BUILDING CODE OF AUSTRALIA COMPLIANCE ASSESSMENT REPORT

RESIDENTIAL FLAT BUILDING WITH BASEMENT CARPARK

IVANHOE ESTATE - LOT C4, EPPING ROAD, MACQUARIE PARK

REPORT NO. ▶ 11067.3

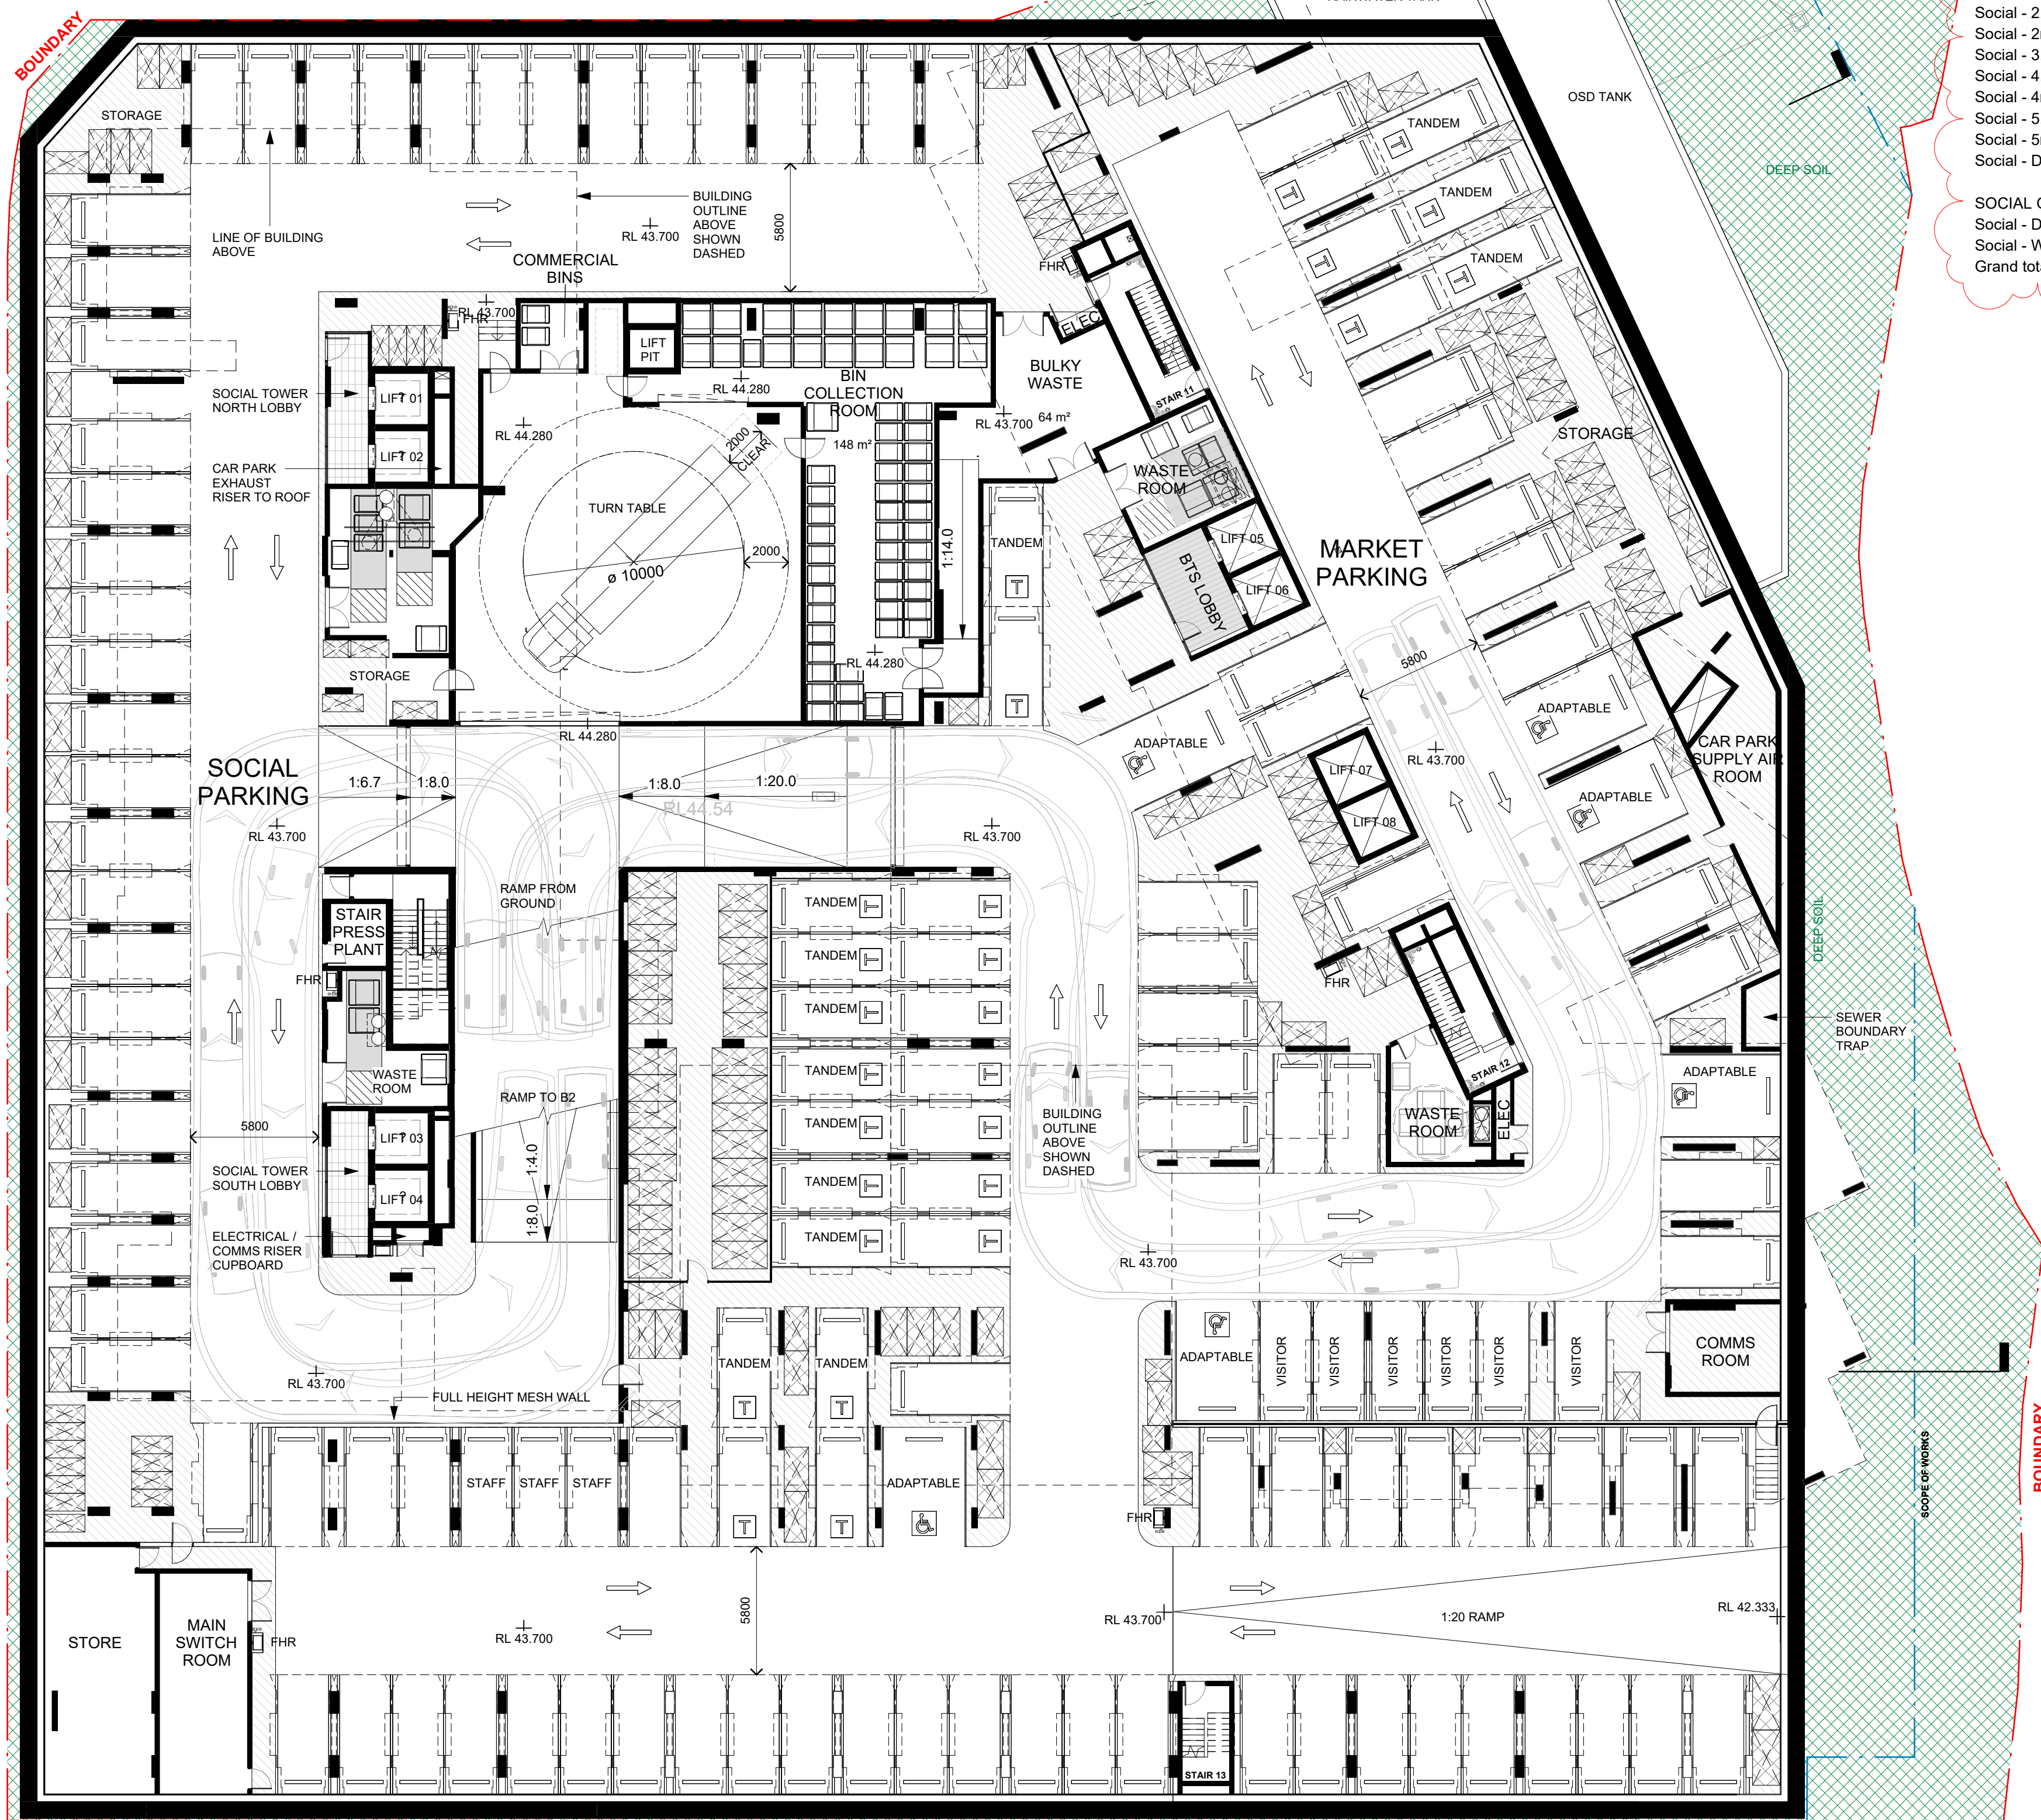
BCA Clause	Deemed-to-Satisfy Provision to be addressed
	<p>A Fire Engineered Performance Solution may be required to omit insulation rating for hydrant and sprinkler main that penetrate the landing of the scissor stair.</p>  <p>Fire Stopping Of Cast In Conduits is addressed in the Draft FEBQ, dated December 2022</p>
<p>D2D5 Exit travel distances [2019: D1.4]</p>	<p>Basement 2</p> <ul style="list-style-type: none"> - Distance to an exit is greater than 40m, maximum being 54m. <p>Basement 1</p> <ul style="list-style-type: none"> - Distance to a point of choice is greater than 20m, maximum being 23m. - Distance to an exit is greater than 40m, maximum being 50m. <p>Ground Floor</p> <ul style="list-style-type: none"> - Distance to a point of choice is greater than 20m, maximum being 23m. <p>Level 1 & 2</p> <ul style="list-style-type: none"> - Distance to a point of choice is greater than 6m, maximum being 17.3m.

BCA Clause	Deemed-to-Satisfy Provision to be addressed
	<p>Level 3 - 23</p> <ul style="list-style-type: none"> - Distance to a point of choice is greater than 6m, maximum being 11.00m.
D2D6 Distance between alternative exits [2019: D1.5]	<p>Basement 2</p> <ul style="list-style-type: none"> - The distance between alternative exits is greater than 60m, maximum being 80.3m. <p>Basement 1</p> <ul style="list-style-type: none"> - The distance between alternative exits is greater than 60m, maximum being 76m. <p>Social Building</p> <p>Level 1-16</p> <ul style="list-style-type: none"> - The distance between alternative exits is less than 9m, being 8.68m (southern) and 5.45m (northern).
